DECISION DELEGATED TO HEAD OF PLANNING

Application No: H12-0546-26 **Applicant:** Mr S Butler

Proposal: Proposed dwelling and detached garage - approved under H12-0930-24. Modification to Condition 2 to allow amendments to previously approved plans and amendment to the wording of Condition 5 to remove the reference to the BNG enhancement area

Location: Sunindale Marriots Gate Lutton

Proposed Site Plan 1:500

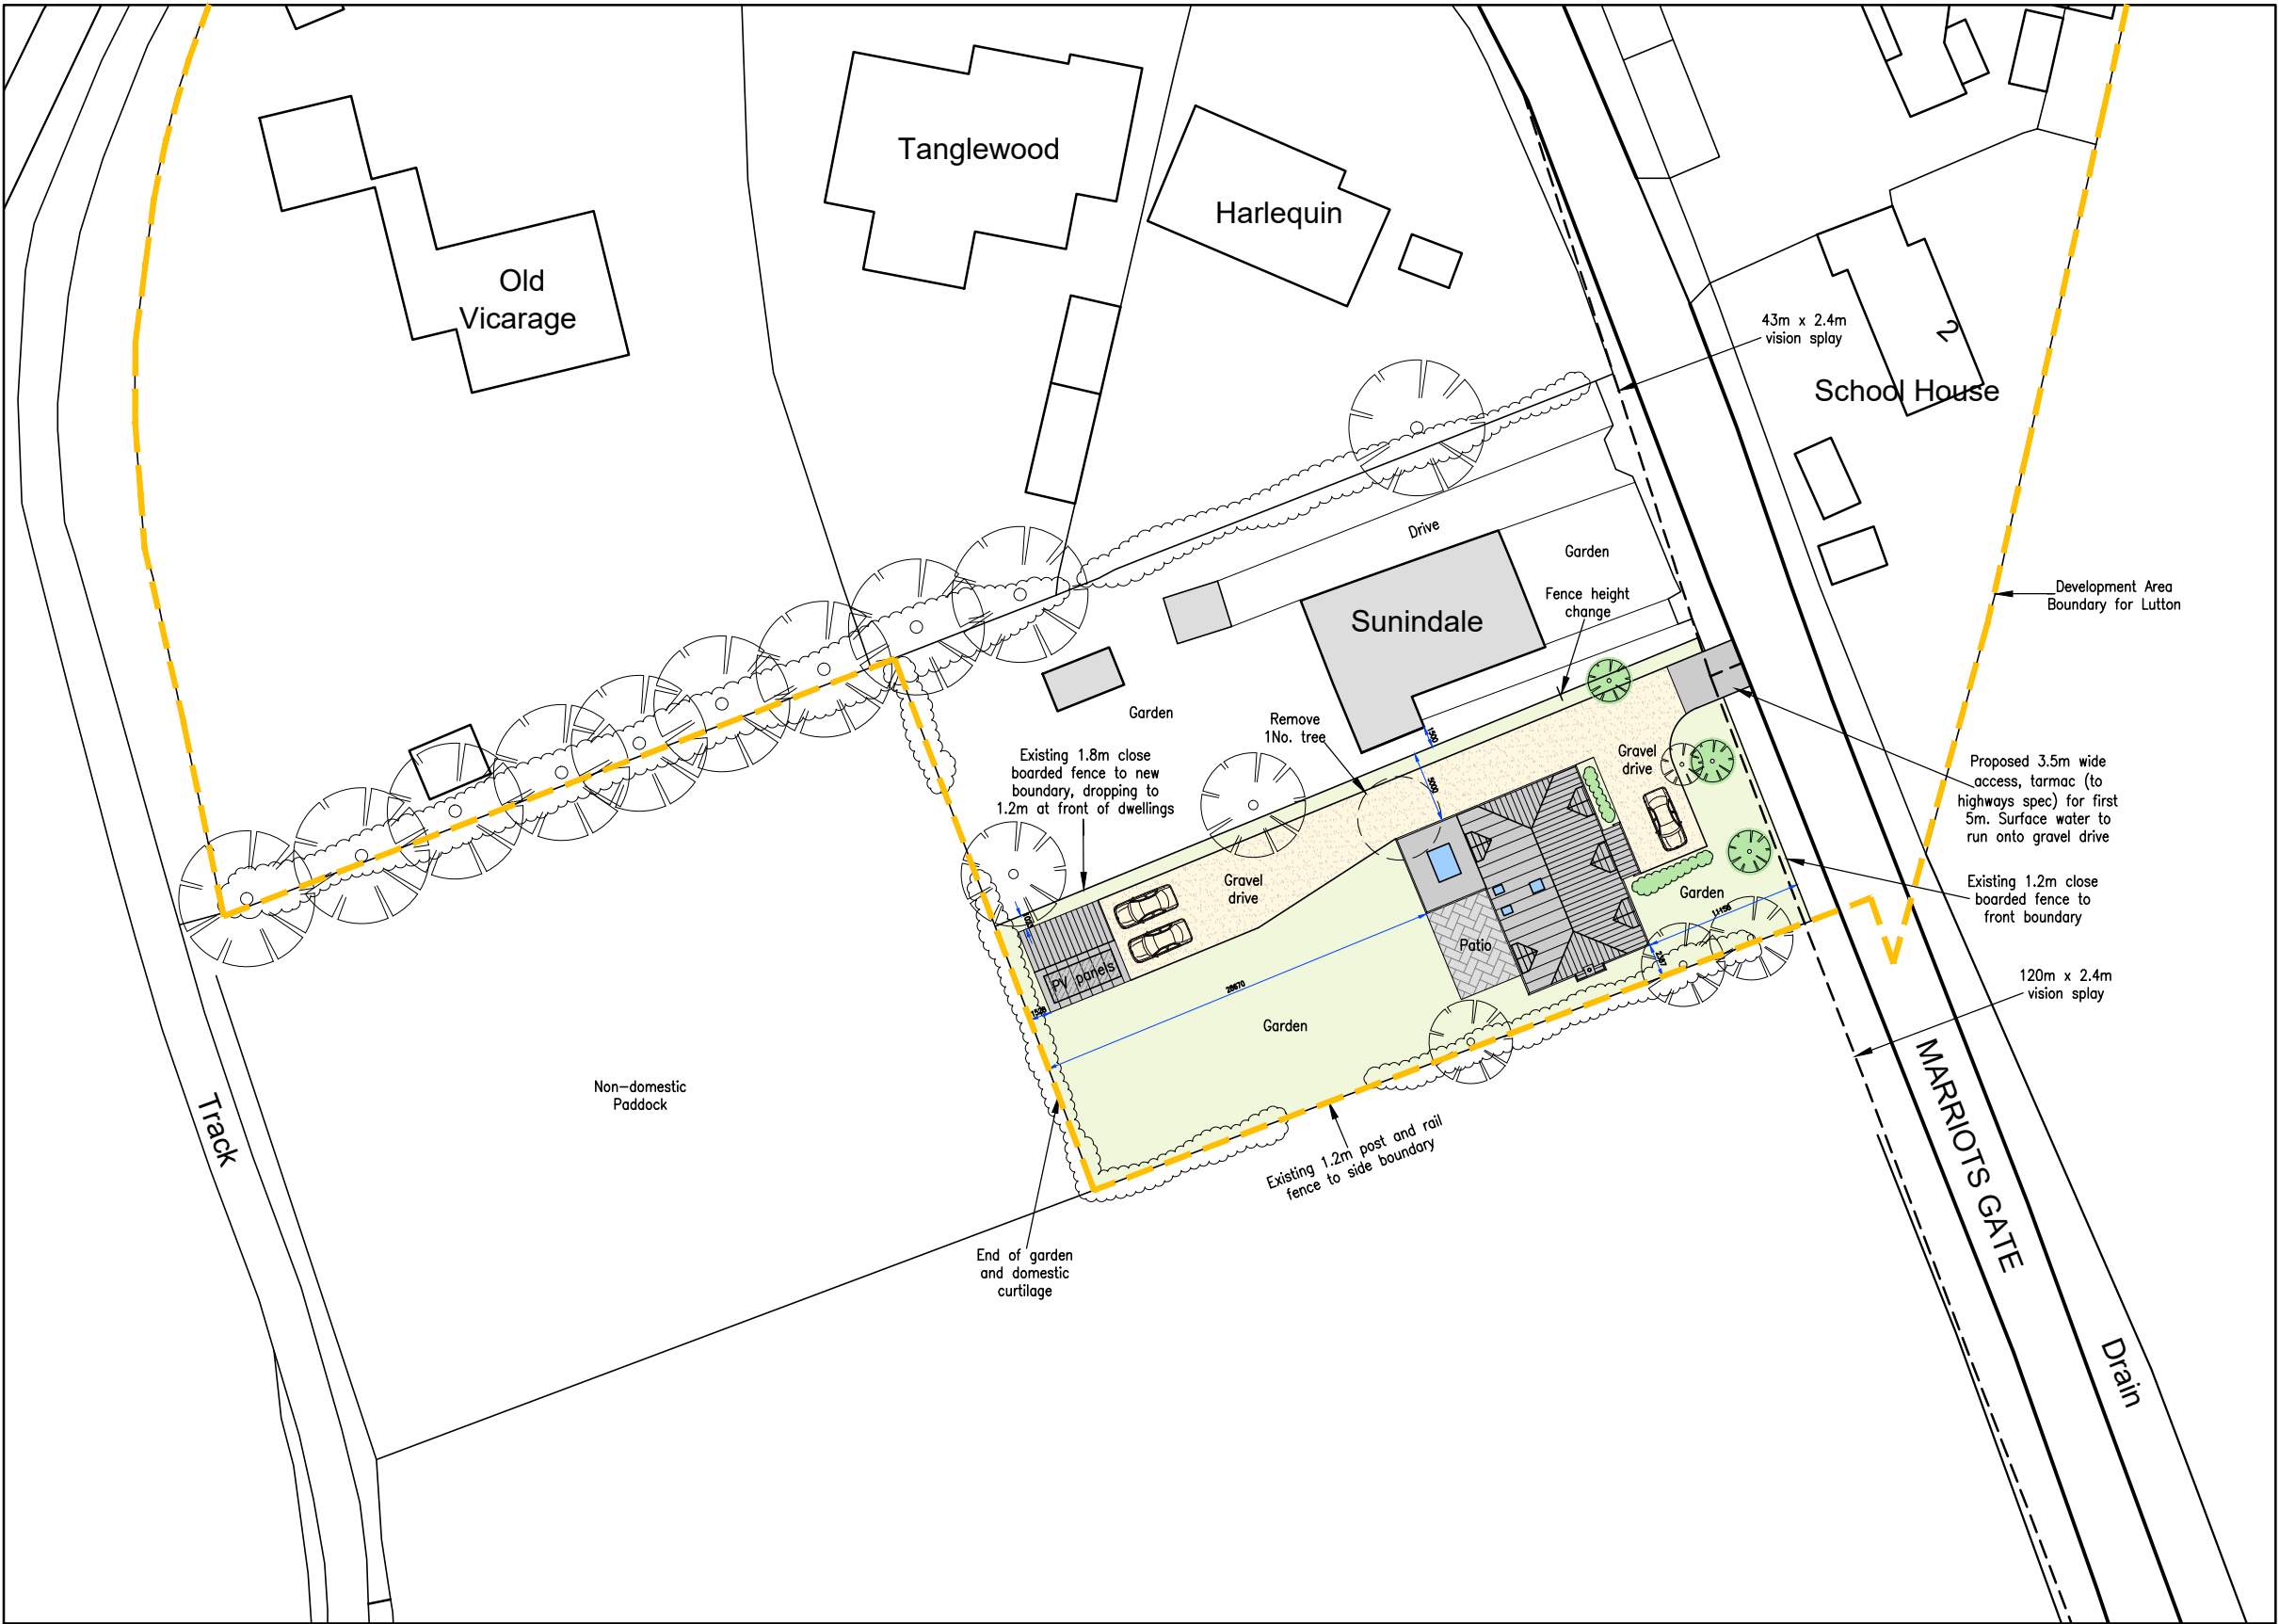
Within planning permission H12-0930-24 condition 2 set out the approved plans, including the approved site plan (ref: 6965/02E). Within the approved site plan, the western portion of the site was labelled as 'Non-domestic paddock (Used for BNG enhancement, see report)'. This is because the western portion of the site was proposed to deliver the necessary Biodiversity Net Gain (BNG) habitat units.

The approved site plan still refers to a BNG enhancement area to the rear of the site and as such, it is considered appropriate to accept the amended site plan that has been submitted with the current application as the western portion of the site has been re-labelled to remove reference to the deliver of BNG. Instead, the area is labelled only as 'Non-domestic paddock'. There is an annotation within the amended site plan to indicate where the rear garden ends and as such, the amended site plan is considered to be suitable.

Although condition 5 doesn't require BNG to be provided within the BNG area, it is understood that an amendment to the wording of the condition is sought in the interests of clarity. Therefore, it is considered appropriate to amend the wording of condition 5 to remove the reference to a BNG area. The site plan makes it clear where the end of the garden and domestic curtilage ends, and this excludes what was formerly the BNG area.
